Chullora Materials Recycling Facility

Environmental Impact Statement (SSD-10401)

Appendix F Building Code of Australia Assessment Report

BCA ASSESSMENT REPORT

# PART SITE PLAN

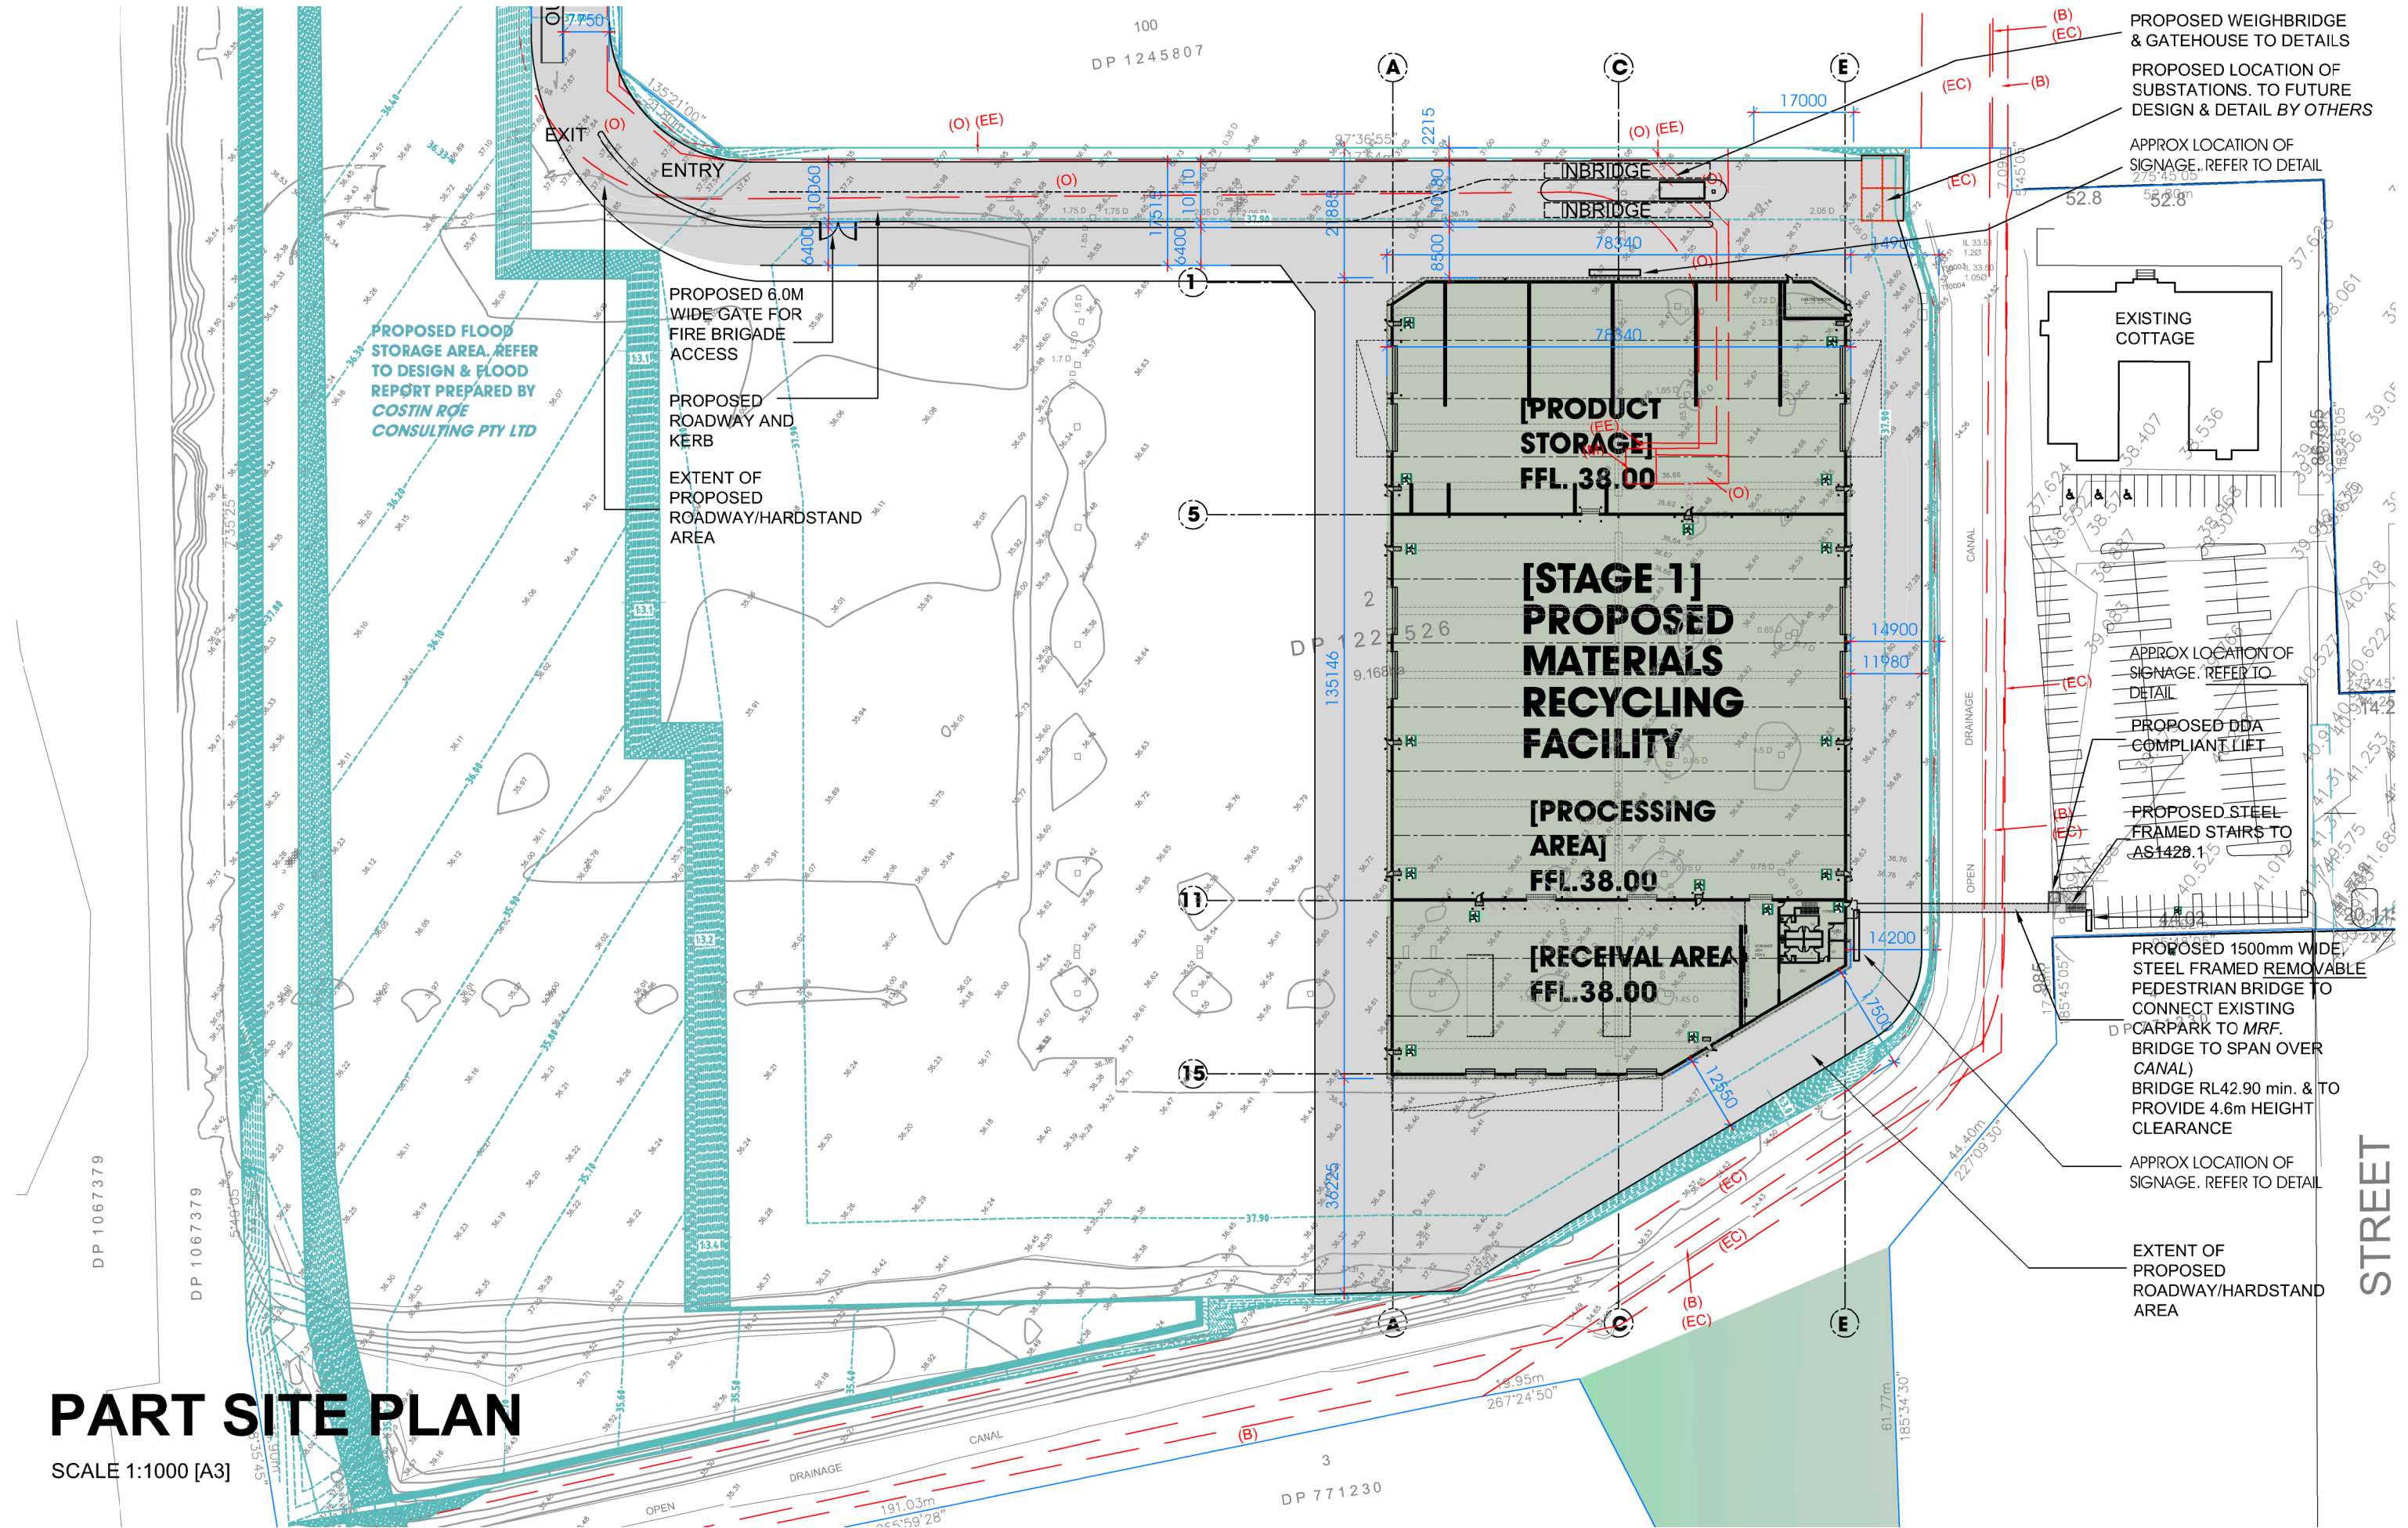
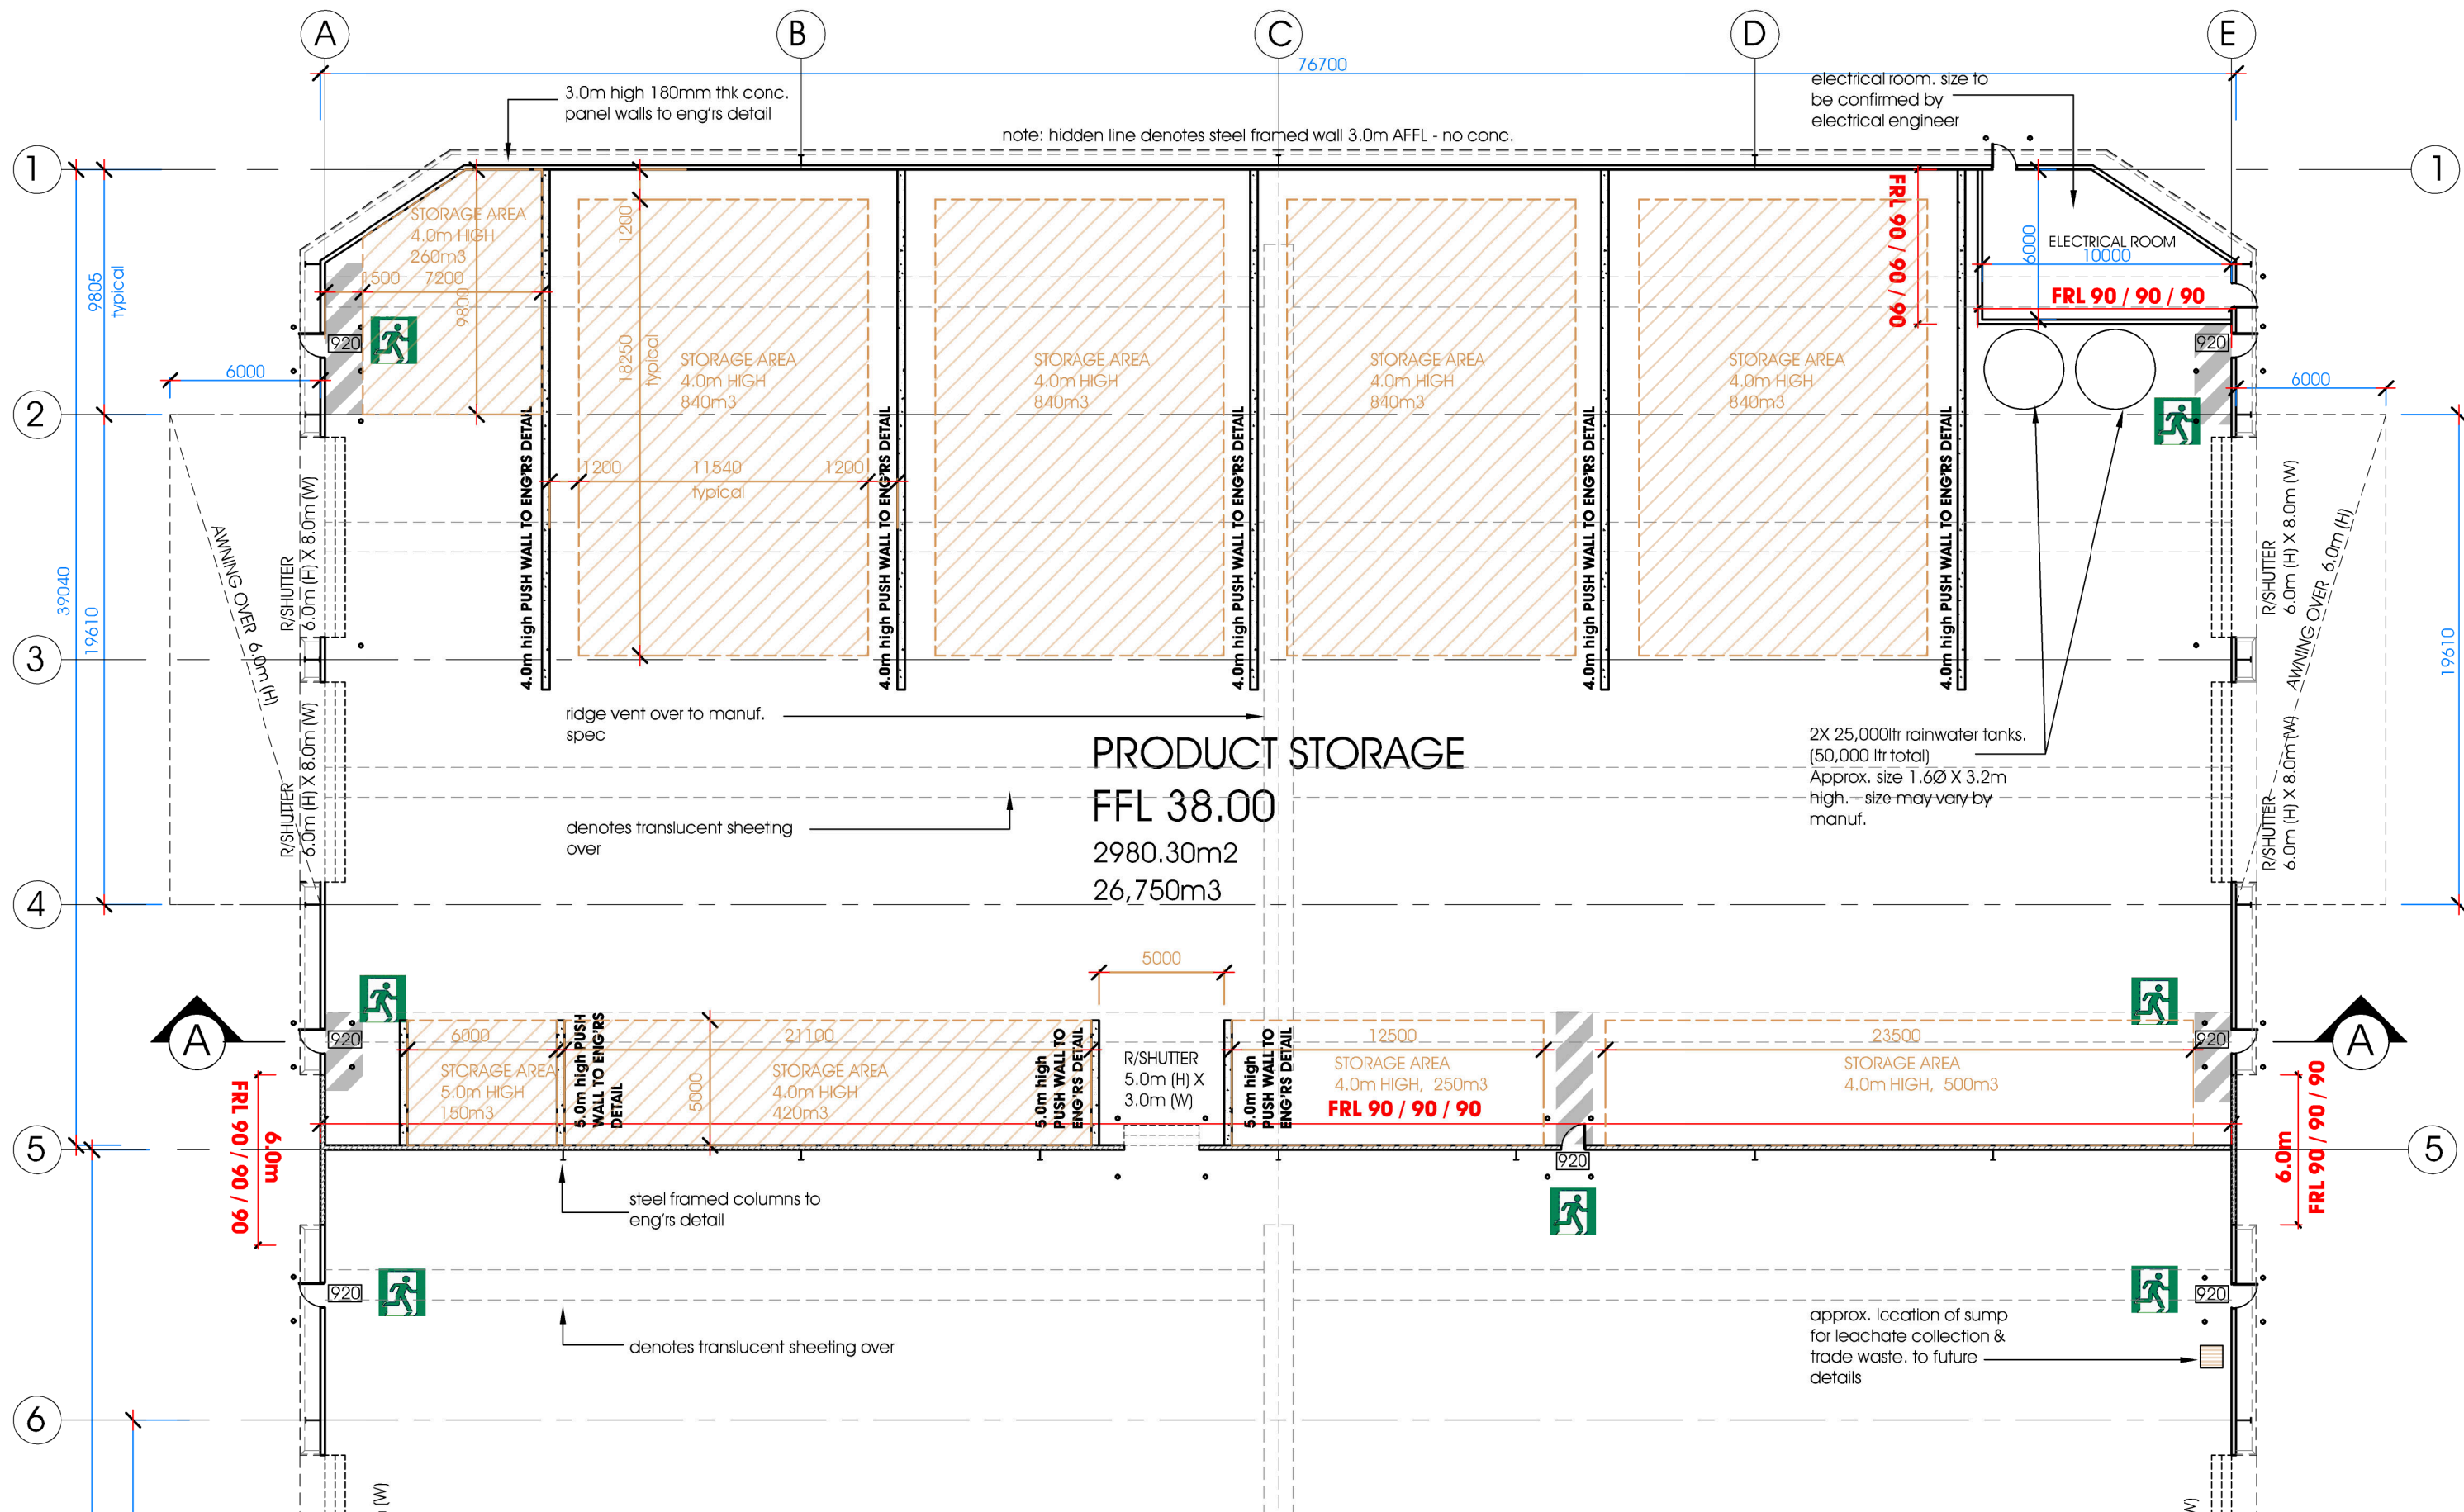
BCA Clause C2.4 (Perimeter Vehicular Access)	<p><u>BCA Clause C2.4</u> specifies the requirements for perimeter vehicular access to Large Isolated Buildings. Furthermore, the perimeter access roads and turning bays will need to be designed to comply with the BCA and Fire & Rescue NSW Fire Safety Guideline (Access for Fire brigade vehicles and fire fighters)</p> <p>In this regard, the following areas have been identified as matters which may be requiring further design consideration and/or justification via Performance Solutions by the project Fire Safety Engineer:</p> <ol style="list-style-type: none"> The Site (Secured Entry/Exit Points) – The Buildings will have perimeter vehicular access roads which will require emergency vehicles to pass by secured entry points and past the entry-weighbridge and out-bridge structures along the Northern sides of the site. Furthermore, these locations are likely to have reduced widths under 6m (approximately 3.2m) and kerbs that could hinder appliance access, External Hardstand – Where external stock piling is proposed, the perimeter access roads are to be line marked to ensure they are maintained at all times and the perimeter access roads should be designed with enhances provisions to cater for large emergency services response (e.g. Multiple alarm and multiple agency attendance – including protracted Hazardous extraction response for the containment and removal of contaminated fire water run off). The hardstand areas above the flood basin areas are to be designed to accommodate the loads of fire brigade appliances or be restricted from access with permanent barriers and signage. Warehouse Building A (Awning's)– The required 6m perimeter access road necessitated passing underneath Awning structures along the Southern side <u>and</u> potentially on the Eastern and Western sides of the site and the heights are to achieve a minimum height of 4.5m,

<p>d) Warehouse Building A (Overhead Bridge/Walkway) – The required 6m perimeter access road necessitated passing underneath the proposed overhead walkway/bridge structure proposed to connect the offices along the Eastern side and the heights are to achieve a minimum height of 4.5m,</p> <p>Fire Engineered Performance Solution: Notwithstanding the above, it is understood that the design team will obtain a Performance Solution prepared by a C10 Fire Safety Engineer to rationalise the proposed vehicular access departures accordingly. In this regard, the report will need to demonstrate compliance with BCA Performance Requirement CP9 and be prepared to the satisfaction of the Registered Certifier and Fire & Rescue NSW at the Construction Certificate stage.</p> <p>Note 1: Architectural and Civil details and design certification to the satisfaction of the Registered Certifier and Fire Safety Engineer are to be provided with the CC application which satisfy the provisions of the Fire & Rescue NSW Fire Safety Guideline (Access for Fire brigade vehicles and fire fighters) https://www.fire.nsw.gov.au/gallery/files/pdf/guidelines/vehicle_access.pdf.</p> <p>Note 2: Design team are encouraged to consider the enhances requirements nominated for waste facilities as listed under Fire & Rescue NSW Fire Safety Guideline (Fire Safety in Waste Facilities) https://www.fire.nsw.gov.au/gallery/files/pdf/guidelines/guidelines_fire_safety_in_waste_facilities.pdf</p> <p>Note 3: Architectural details, specifications and design certifications are to be prepared by a suitably qualified design practitioner (Registered Architect) and submitted to the satisfaction of the Registered Certifier at the Construction Certificate application stage. Where Fire Safety Engineering is proposed, a copy of the Fire Engineers Report prepared by a C10 Certifier – Fire Safety is to also be provided.</p>
